Application No: AB/134/21/HH  
Site Address: 11 Wheelwrights Close Arundel BN18 9TA  
Description of works: Installation of 5 triple glazed windows. (This application may affect the character and appearance of the Arundel Conservation Area).

OWPC42368

**Objection**

GENERAL ARRANGEMENT
DRAWING

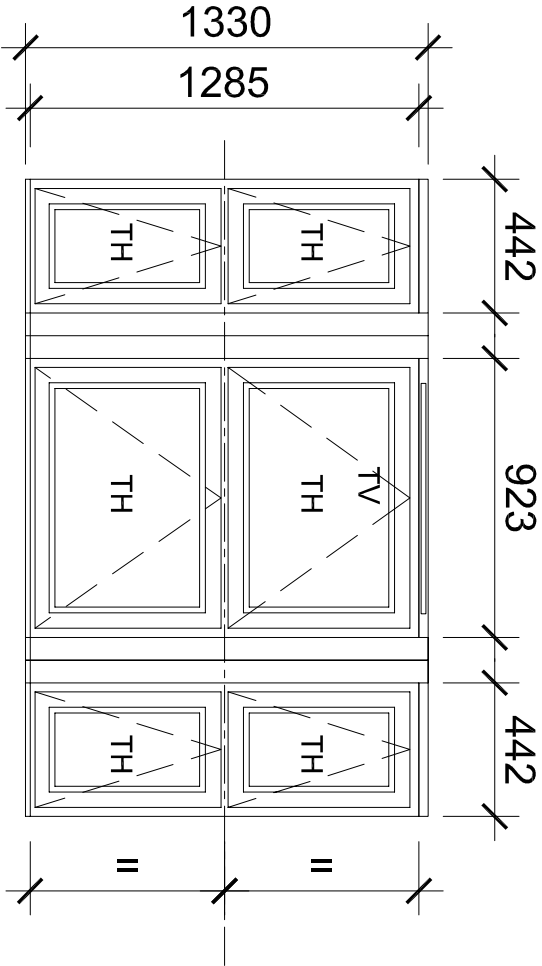
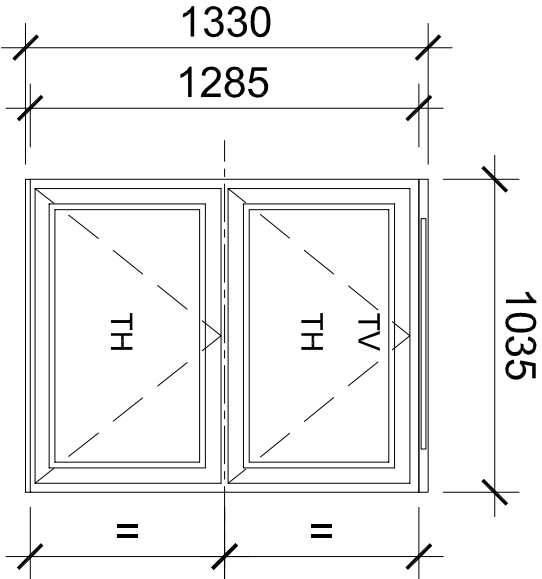
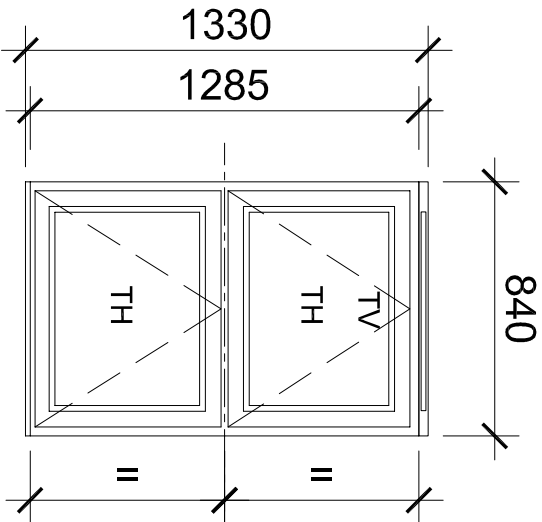
The Panel's objection relates to the operating mechanism of the replacement windows. The existing vertically sliding sash windows are intended to be replaced with windows that have top hung sashes. This will result in the upper and lower sashes being flush; not the lower one inset from the upper which gives a subtle shadow line as in the existing traditional vertically sliding sashes. The central meeting rails of the existing windows have slender proportions whereas the horizontal central members of the new windows will have extremely

bulky proportions.

For the reasons indicated above it is considered important that vertically sliding sashes be used as replacement windows and if the Council agrees then no doubt negotiations could be undertaken with the applicant to achieve this, prior to the grant of any planning permission.
